Land at Tile Barn Farm, Hill Lane, Barnham PO22 0BL

This letter accompanies an application on behalf of Mrs Lonsdale, for amendments to the dwelling approved on appeal under reference BN/24/20 for the erection of 1 no. dwelling and formation of new vehicular access on land adjacent to her property at Tile Barn Farm.

PROPOSED PLANS
Dwg. No. 03

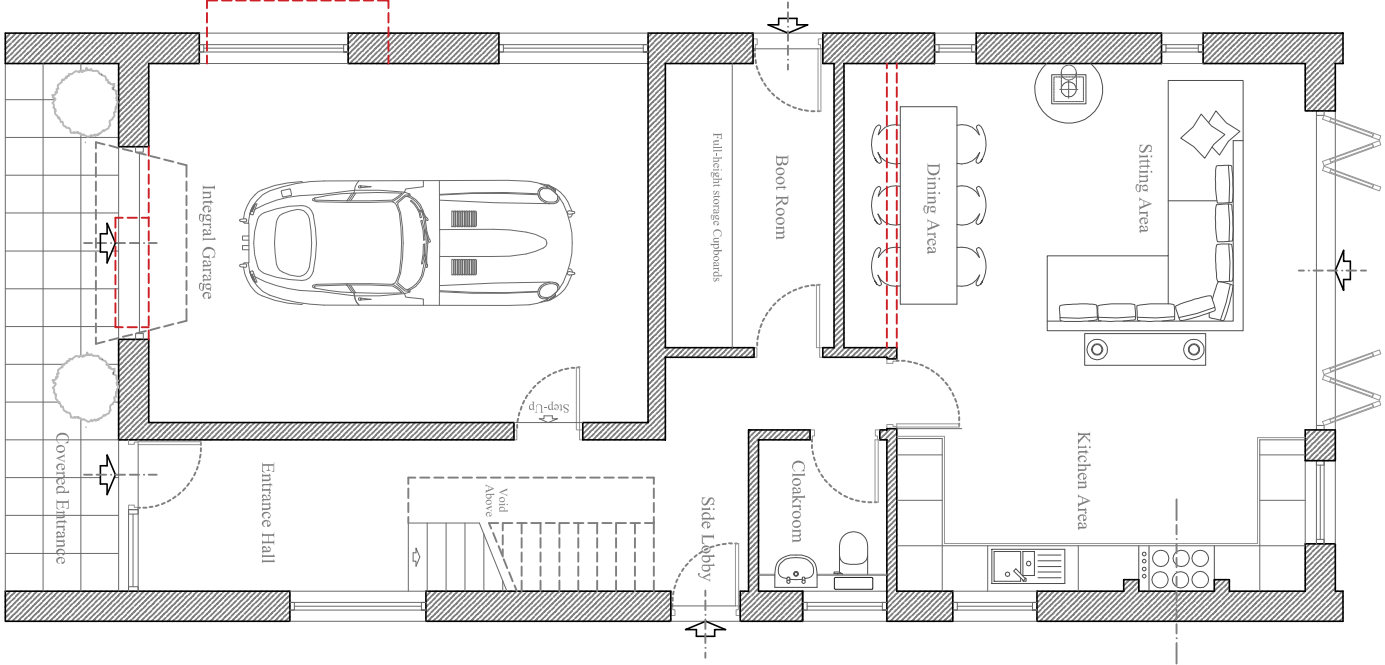
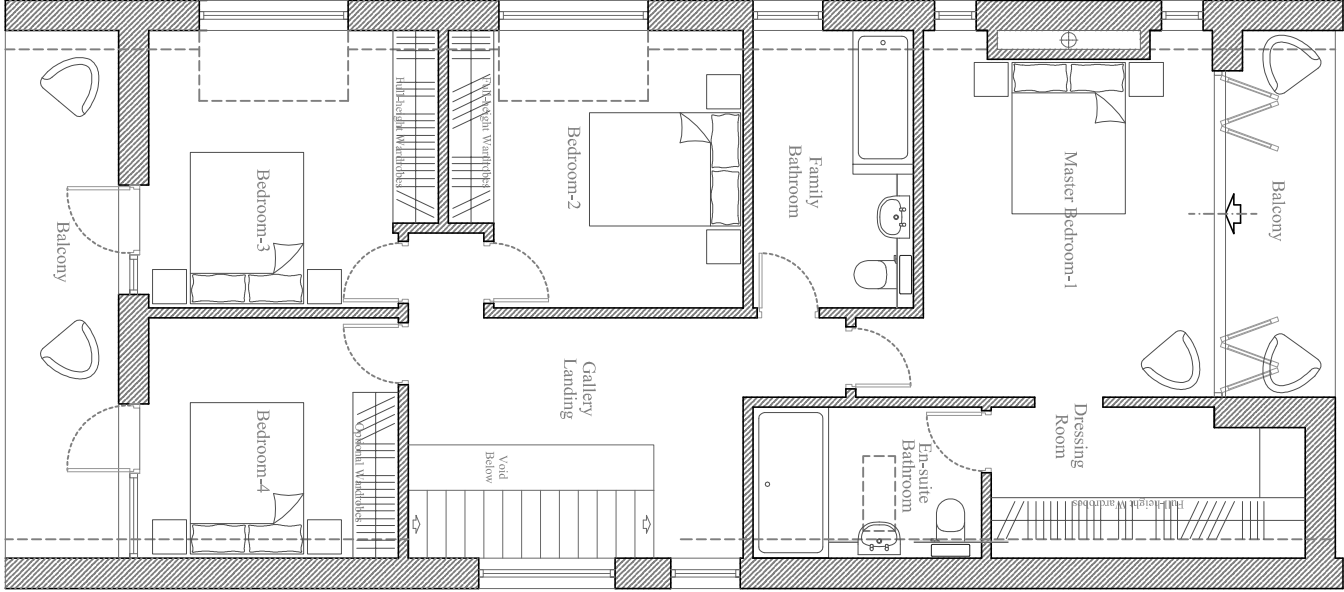
- Formation of integral garage in western end of the building with new garage door in place of sitting room window and infill section of wall on its north side. Replacement of bay window on north elevation with non-projecting smaller window.

- Wrap around glazing on the north east corner of the ground floor altered to bi-fold doors on the east elevation and new windows at ground and first floor level on the north elevation to match those adjoining.

PROPOSED ELEVATIONS
Dwg. No. 04

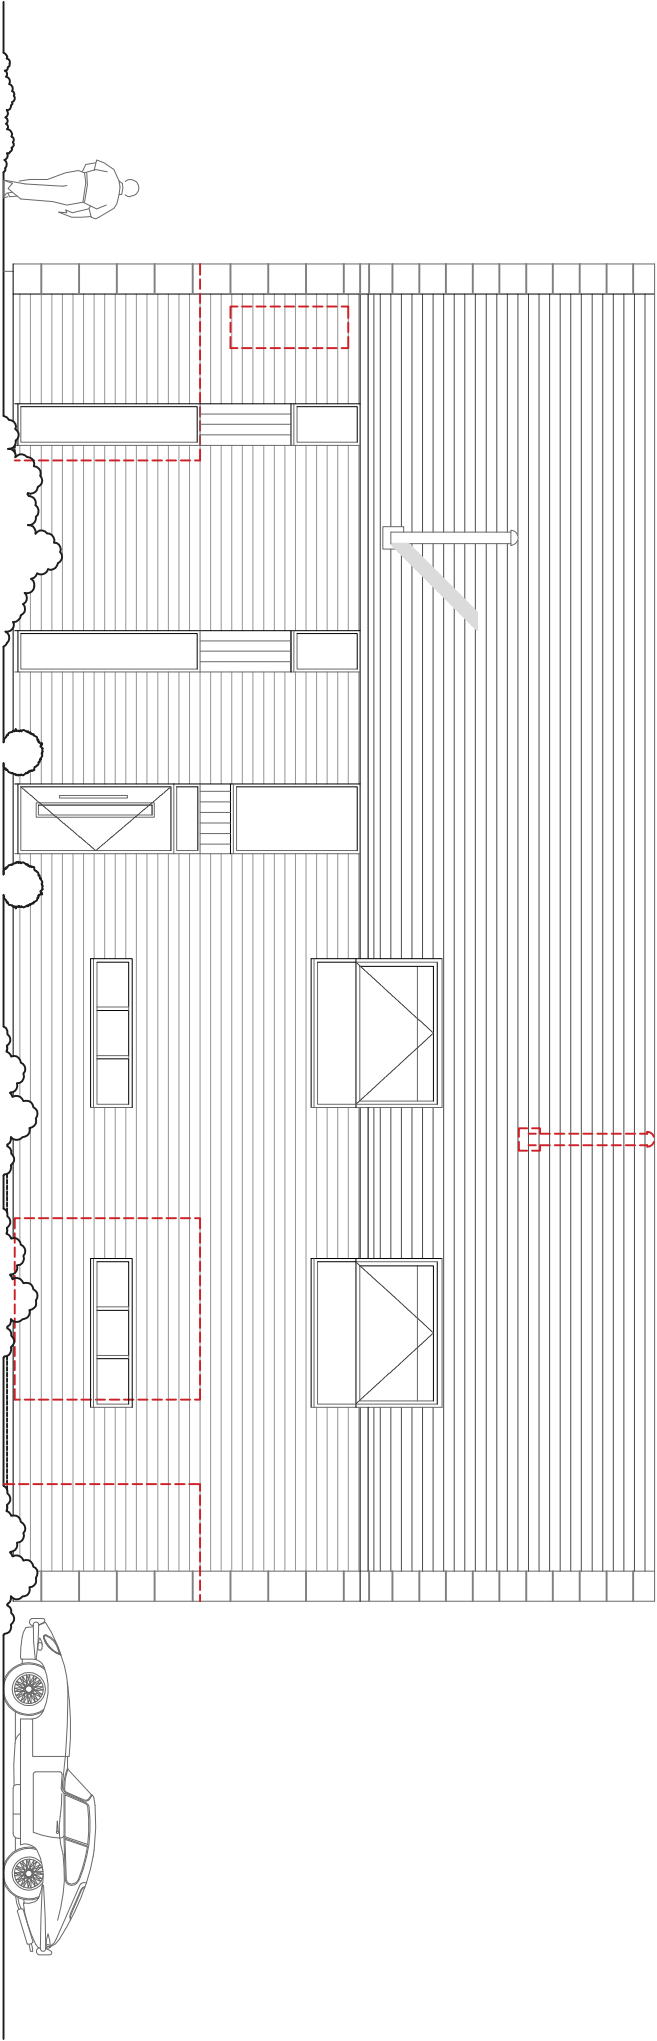
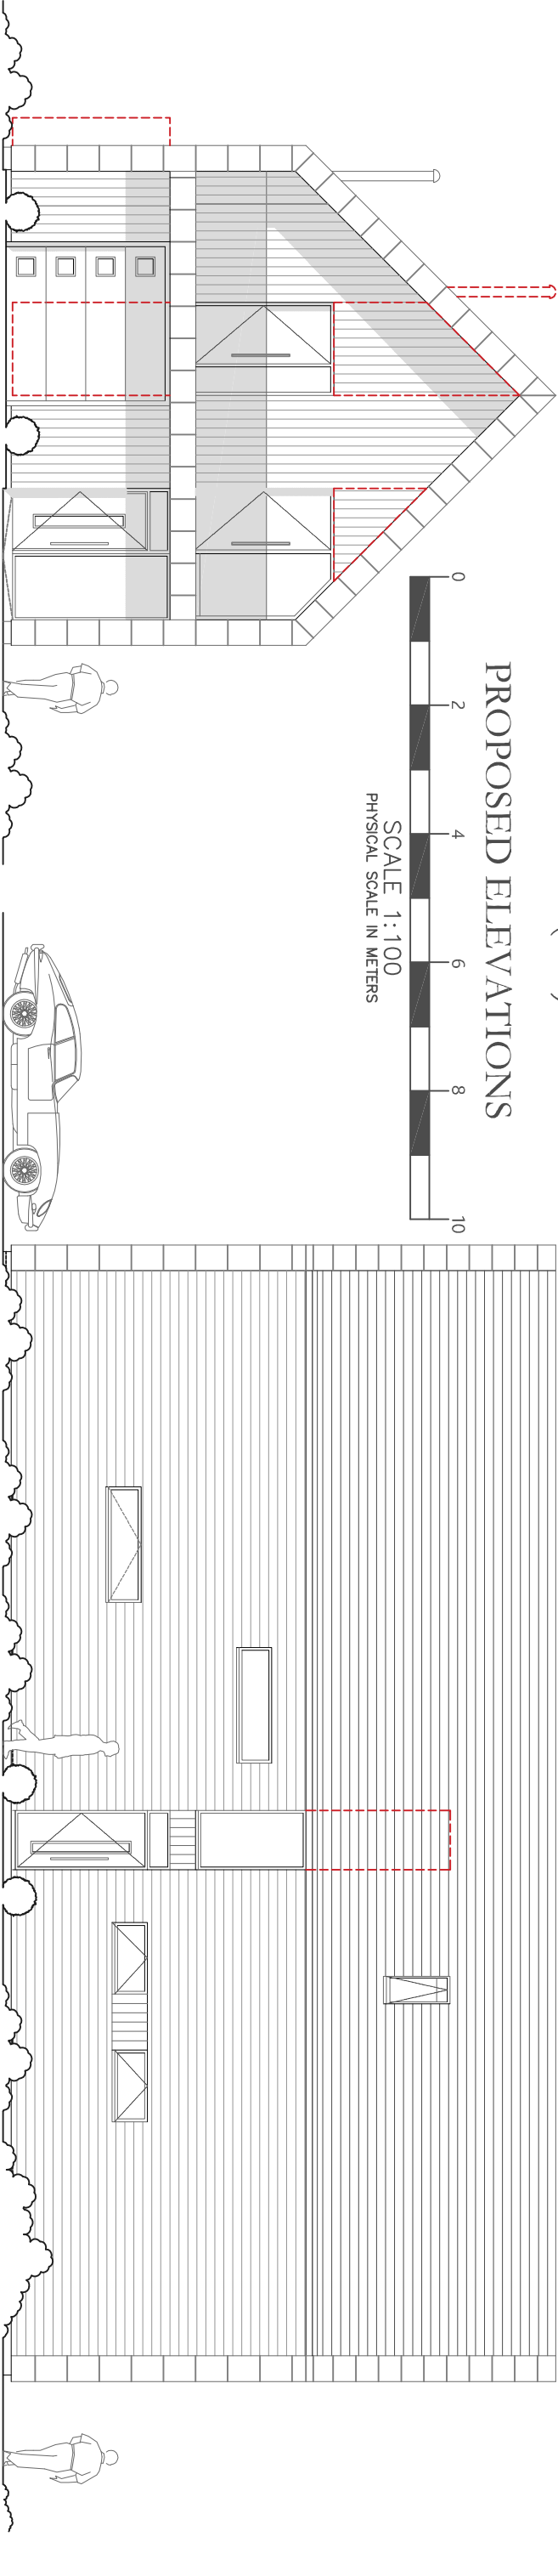
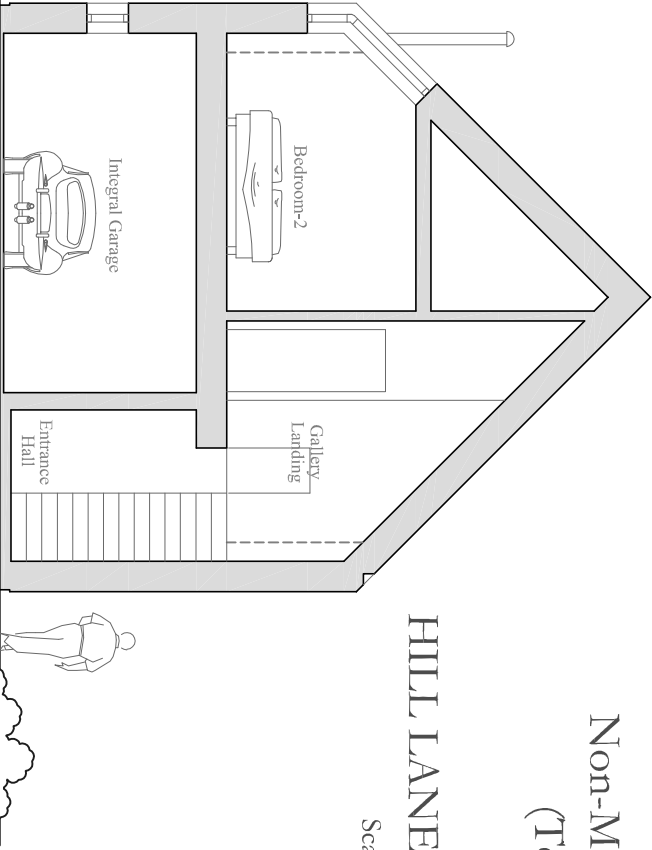
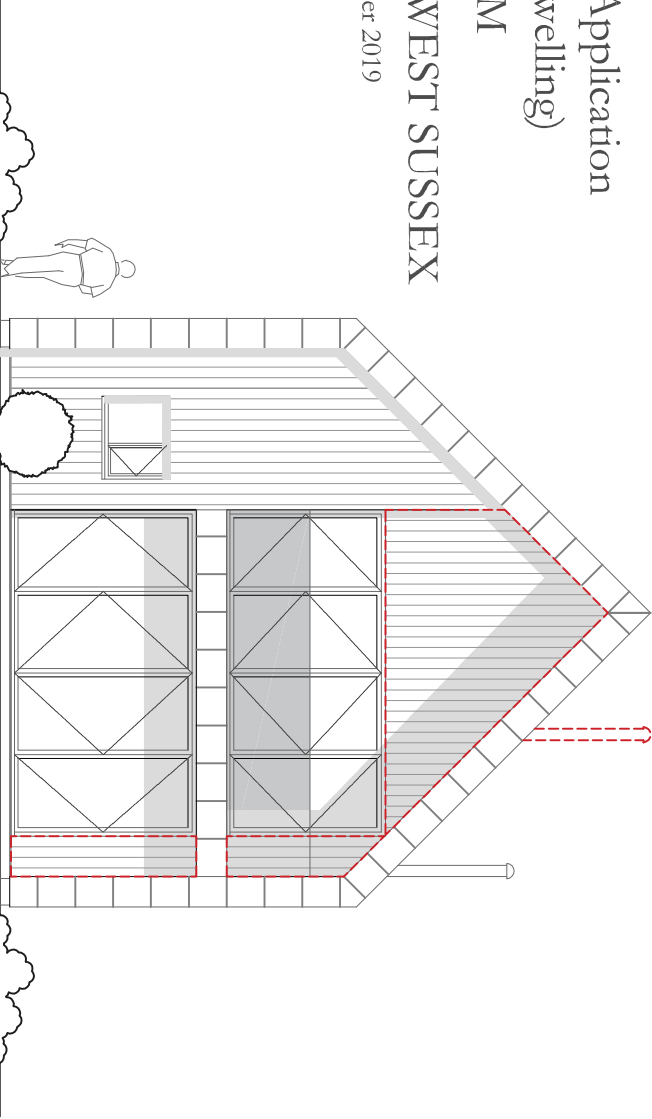
- Reduction in fenestration at first floor level on west elevation above the doors.
- Fenestration reduced on south elevation by removal of element that extends into the roof.

- On the east elevation the fenestration will be reduced at first floor level above the opening doors. The doors are also to be reconfigured and the side opening to the balcony removed.

- The window to bedroom 3 on the north elevation is to be reduced in width.
- Flue to be repositioned.
